N O R T H F A L L S

Offshore Wind Farm

Applicant's Response to the ExA's Proposed Schedule of Changes to the dDCO

Document Reference:	9.106
Volume:	9
Date:	July 2025
Revision:	0

Deep Water Route Cable Installation Areas (Future Dredging Depths) Plan

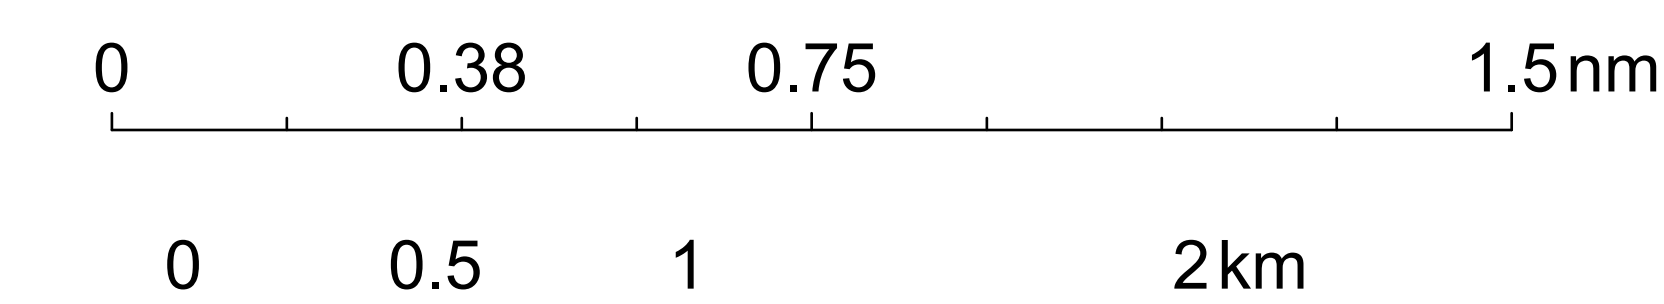
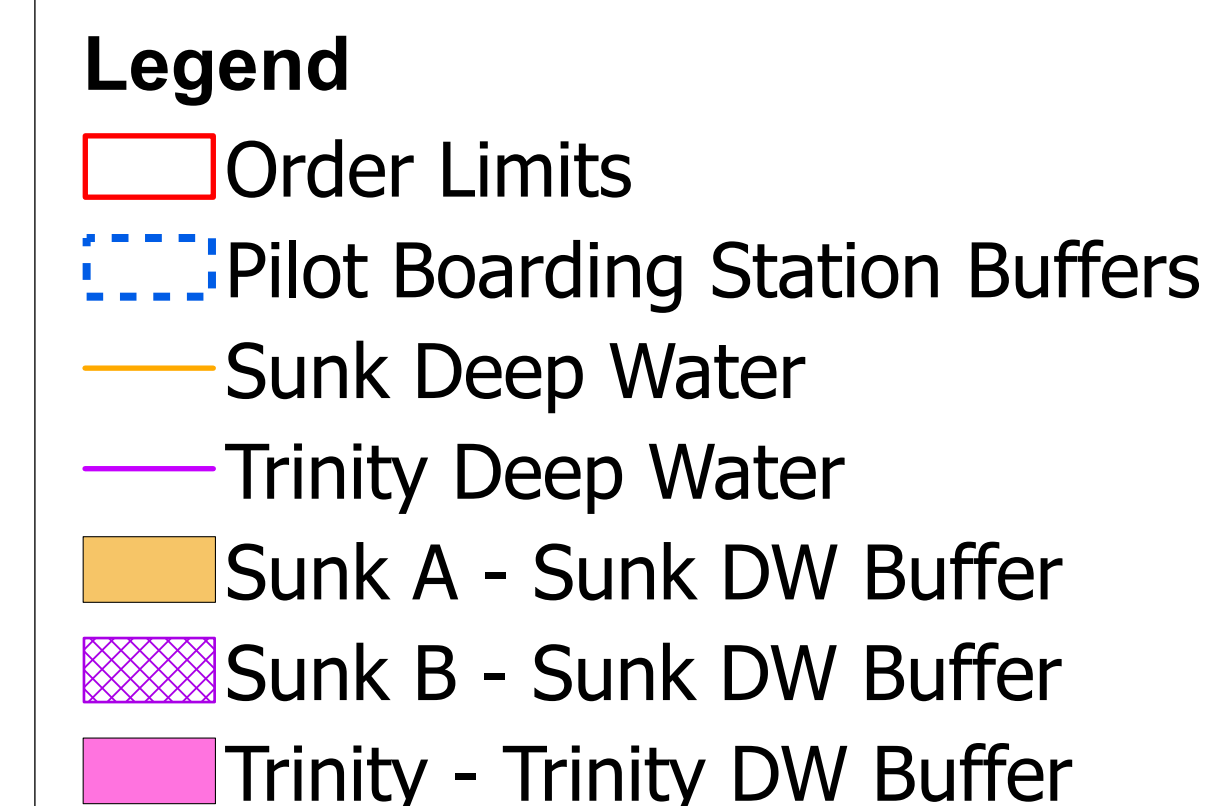
Deep Water Route Cable Installation Areas (Future Dredging Depths) Plan (Rev 0) [REP4-043].	PLA's amendments to Deep Water Route Plan [REP4-043] as described in PLA's [REP5-111] which includes a revised image showing additional areas to be included in green, namely:	The ExA considers this change to be reasonable.	The Applicant updated the Deep Water Route Cable Installation Areas (Future Dredging Depths) Plan at Deadline 6 [REP6-055] to make the area around the sunk pilot diamond (shown coloured blue on that plan) protected from having its depth reduced to any less than -22m by Work No. 3 (see Requirement 2(3) of dDCO [REP6-005]).

ExA's Proposed Changes	ExA's Reasoning	Applicant response
	The majority of the green area will need to allow for dredging to -22m CD and the PLA could otherwise accept the 200m buffer to the south at -19m CD.		This, in effect, gives the same protection as the proposal by PLA, as the area around the sunk pilot diamond extends further than the areas proposed by PLA (even if not using the colour green).
Outline Cable Specification and Installation Plan (OCSIP) [REP4-039]	At paragraph 31 in relation to the Deep Water Routes (DWR) the reference is to the cables being installed and maintained but in paragraph 32 the reference is only to installation. The oCSIP and CSIP must be clear that any commitments relating to the DWRs apply to both installation and maintenance.	The ExA considers this change to be reasonable.	The Outline Cable Specification and Installation Plan has been updated at Deadline 7 (Document Ref: 9.53 (rev 3) to address this point.
